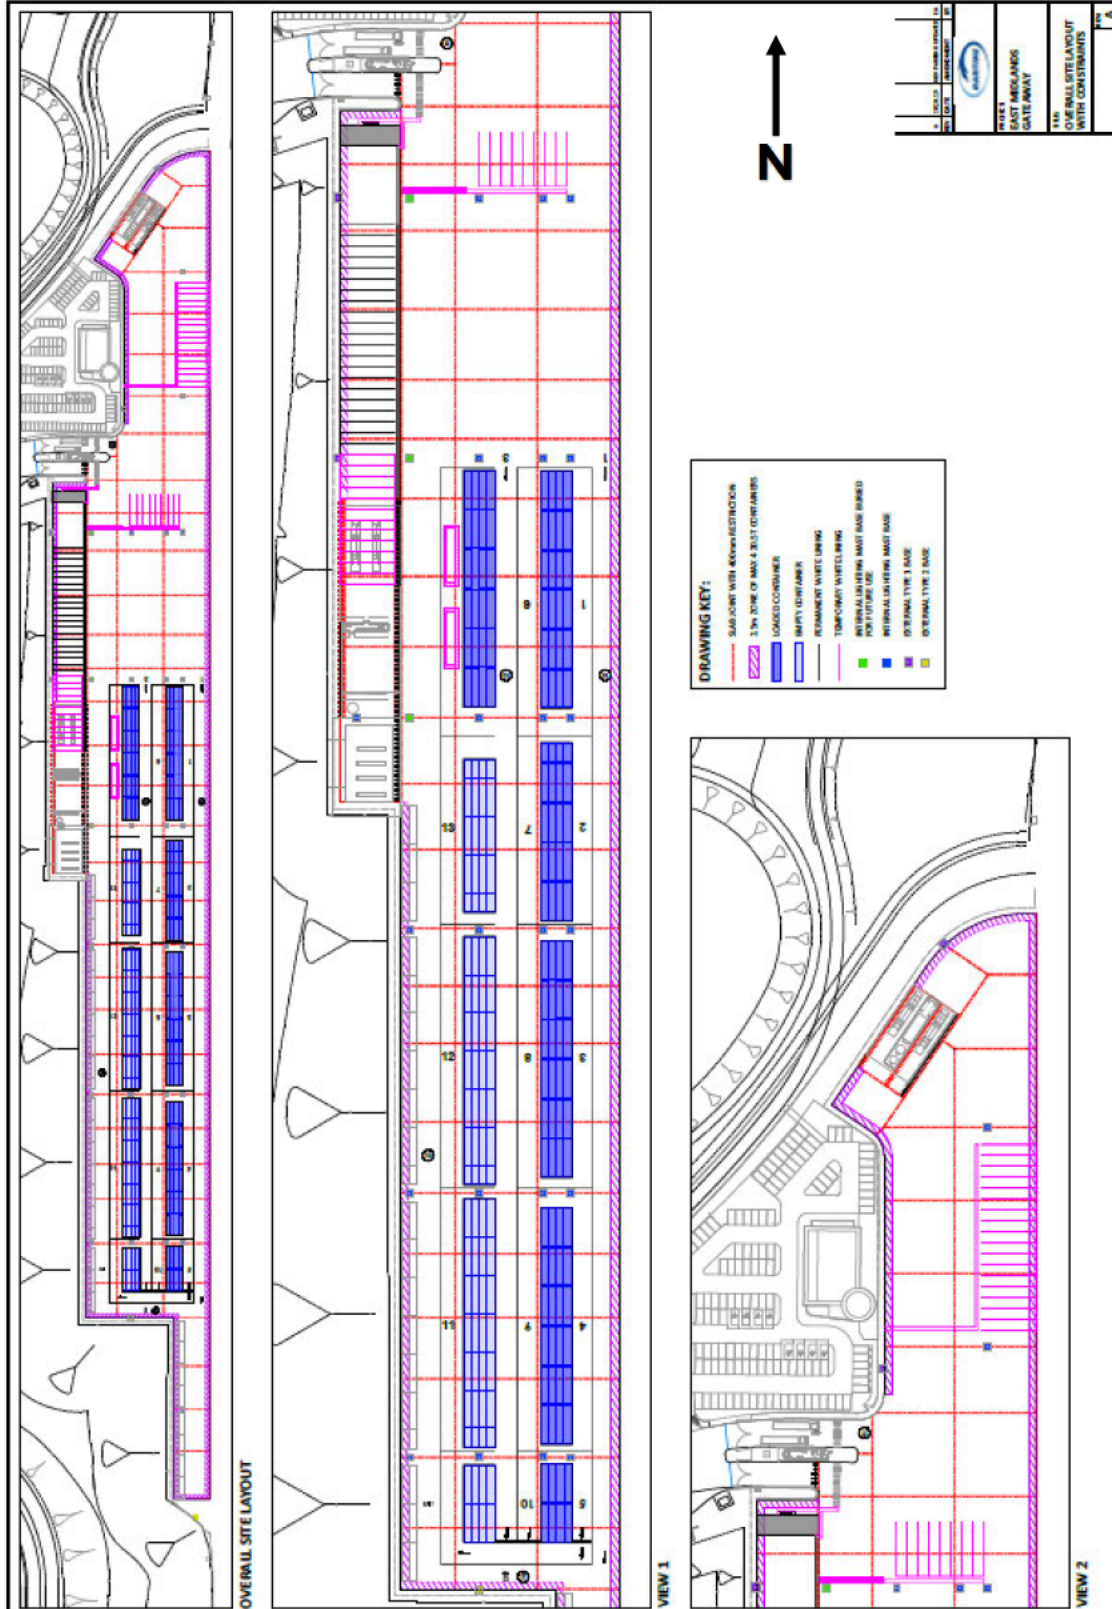
5. The proposed site has little noise attenuation built in – all the “noisy” elements of rail in/out, lorry in/out, container full/empty stack or load all take place along the outside of the buildings, all facing residential or recreational areas. The stacker trucks (EM gateway) are using horn signals to the truck drivers, so with reflection from the warehouse or container walls and no earth bunds and no ground attenuation due to the rail elevation, I think close by residential properties will have continuous disturbance. There is no calculation of wind effects as per the EM Gateway plans ?

Drawing file: TR050007 / TR050007-000866-6.3.14.5 Hinckley NRFI ES Figure 14.5 Main HNRFI Site Concept Foul Water Drainage Strategy.pdf

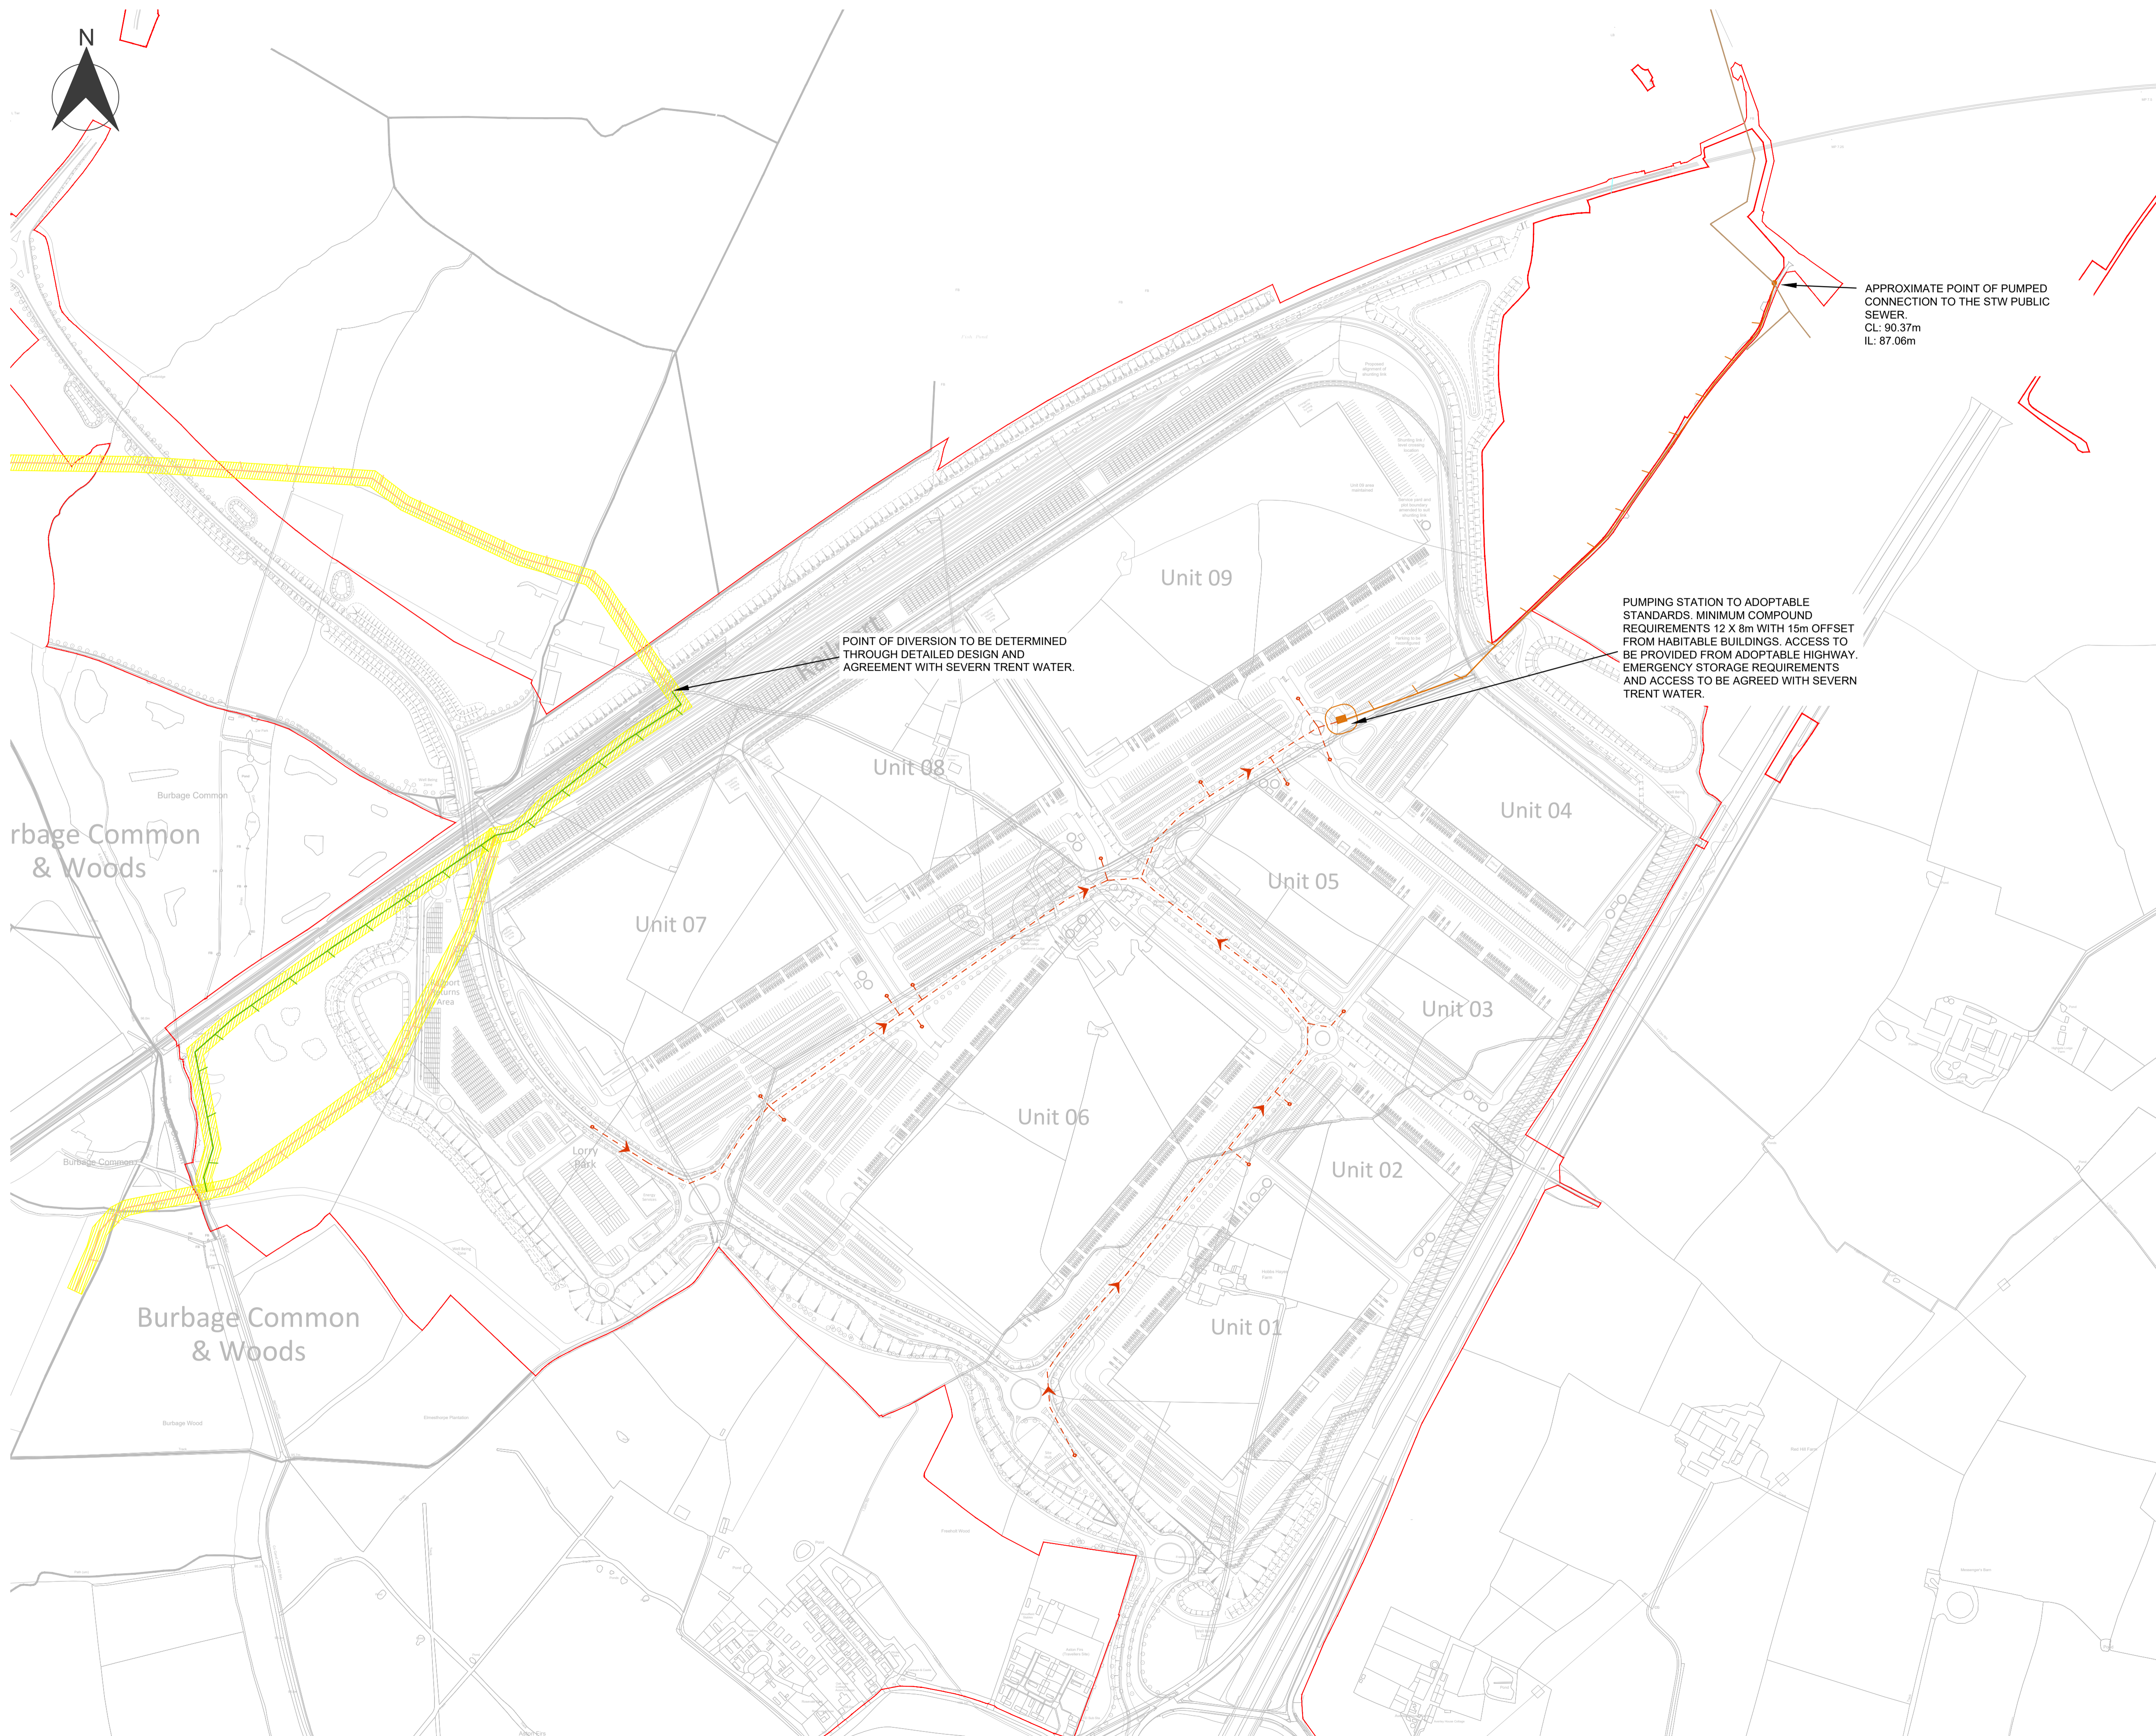
2. The site has a Severn Trent 500mm pressurised sewerage pipe crossing one corner and the mainline rail track. Severn Trent confirmed a 20 metre easement for this pipeline. The latest proposed diversion route shown on “Concept Foul Water Drainage Strategy” drawing still appears to be within the proposed Railport Area ?
